Recommendation Report for Works to Tree(s) on trees subject to a Tree Preservation Order (

REF NO: FP/140/13/T

LOCATION: 29 Links Avenue
Felpham

PROPOSAL: T1 Common Lime - re-pollard at 6 metres above ground level, removing 9 meters of crown above the pollard level; and T2 Common Lime-reduce crown by 5 metres.

T1 - SMALL-LEAFED LIME  
- RE-POLLARD

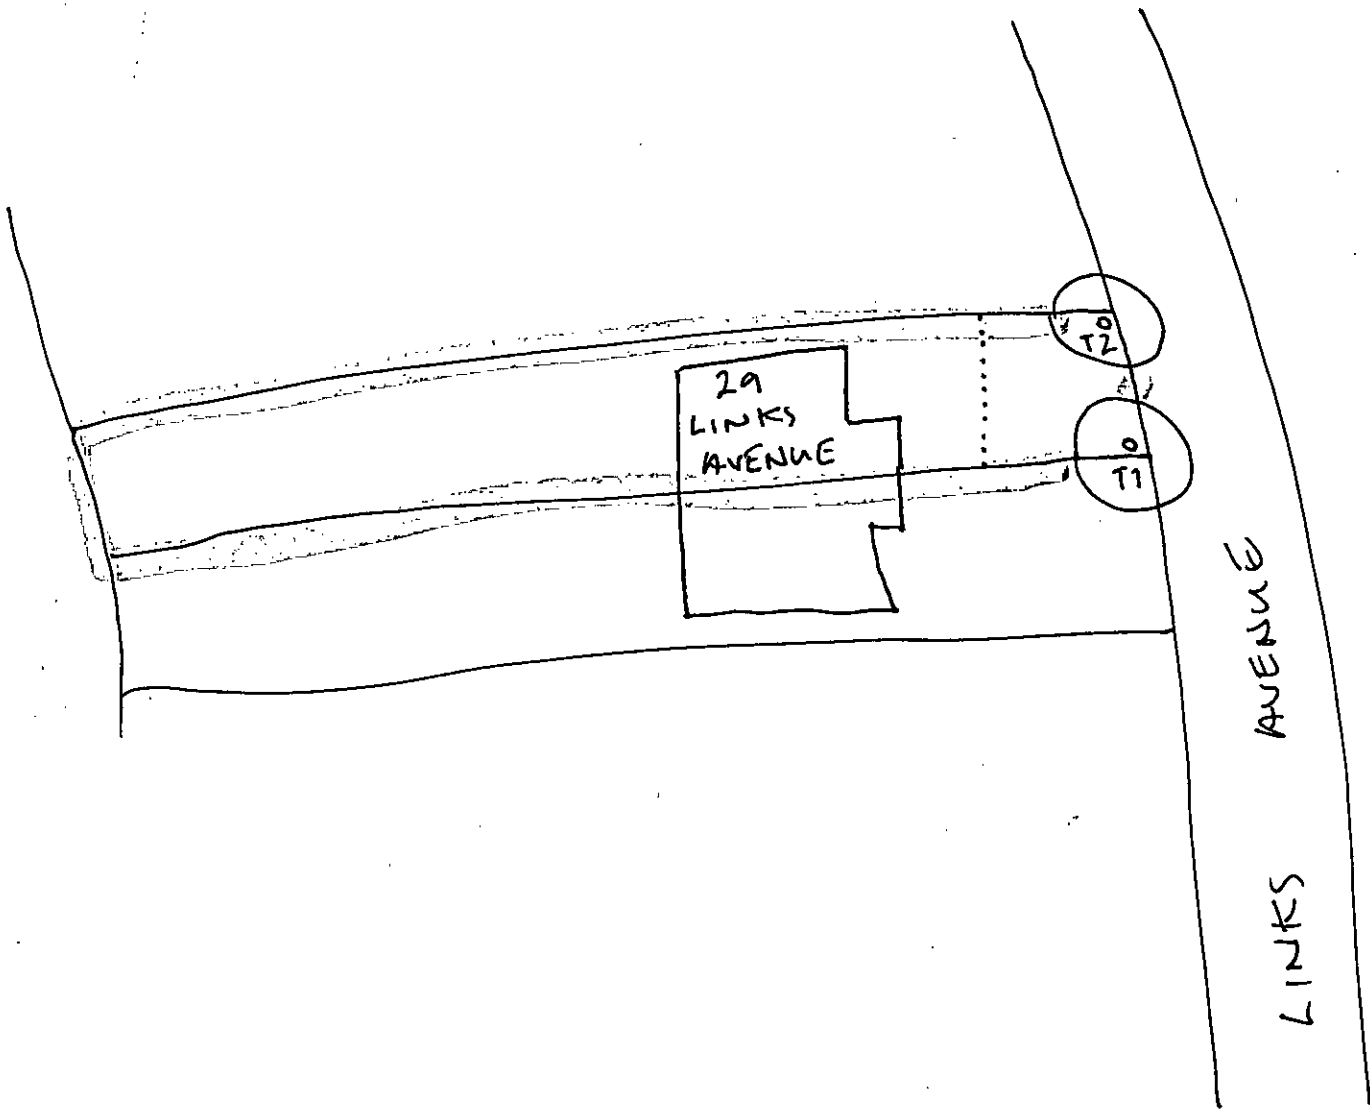
"The two Lime trees grow together and provide a good visual amenity in the street scene and their loss would be noticeable. I did not detect the presence of fungi at either tree's basal areas. However there was evident a juvenile developing Ganoderma fungi bracket. This is a parasitic organism and will destroy live supportive wood tissues. The fungi is emerging below the heavily decaying cavity of the main branching stem located at 3m from the ground of (T1) the Small Leaf Lime tree. This is a concern as it increases the likelihood of stem failure within a shorter period of time. The recommendation to reduce the tree to a 6m standing main stem height in accordance with the consultant's report is therefore acceptable.

The loss of T1's crown would expose the unevenness of T2 the Common Lime. Although there is a need to carrying formative pruning to T2, the cutting down to a similar height of a 6m high main stem is not recommended. It is preferably to retain the presence of tree height by recommending reduction of the crown by 5m to stimulate the production of an even and balance crown from an otherwise asymmetric shape. Recommend: T1 as per tree consultant's recommendations cut to leave main stem height of 6m; and T2 Reduce Crown by 5m, this should be carried out mainly from the North West with little to be pruned adjacent to T1. Wound sizes to be kept small restricting their diameter to 150mm or less. The tree work to T1 is necessary to abate a danger where a 5 days' notice to carry out the work is acceptable. If the crown reduction of T2 is unacceptable then the application for this work should be refused consent."

- 3 The works hereby approved shall involve: (A) T1: As per the Tree Consultant's recommendations namely cut to leave a main stem height of 6m; and (B) T2: Reduce Crown by 5m, this should be carried out mainly from the North West with little to be pruned adjacent to T1. All wound sizes to be kept small restricting their diameter to 150mm or less. All works shall be carried out in accordance with BS3998:2010 "Recommendations for Tree Work".
